Text of email from Tim Townsend (WSCC) to Ivan Cosmai (Mayer Brown) dated 08.03.2022

Principal Transport Planner, County Highways Team – Highways, Transport and Planning
West Sussex County Council, Ground Floor Northleigh, County Hall, Chichester PO19 1RQ

NORTH LITTLEHAMPTON
CENTRAL WETLAND AREA
NORTH CROSSING
GENERAL ARRANGEMENT

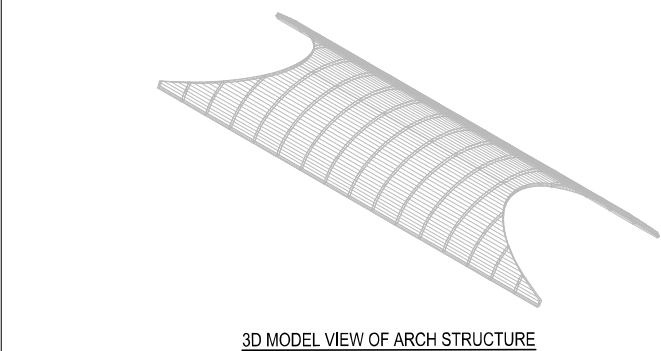
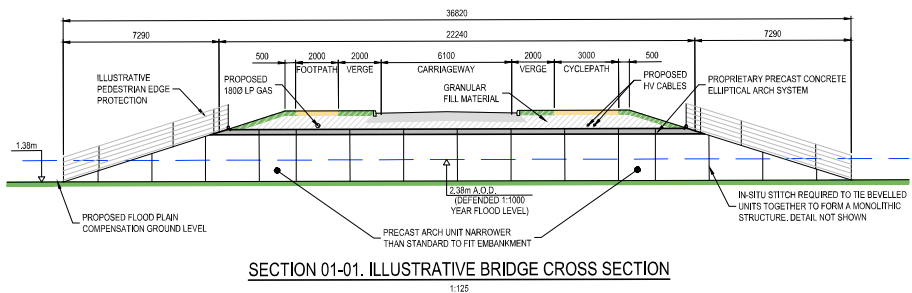
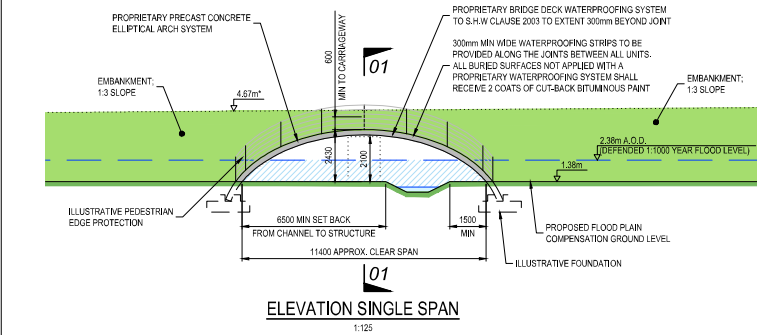
- 2. Guardrail** – I am struggling to find details of guardrail for the Bebo arch. Furthermore, can you provide more detail of the locations, type and heights of the proposed guardrail (dimensions and levels of land/cross-sections alongside the shared-use path running through the central wetland area are most important) and show how these would be LTN 1/20-compliant. *I cannot find this information in your download – please supply.*
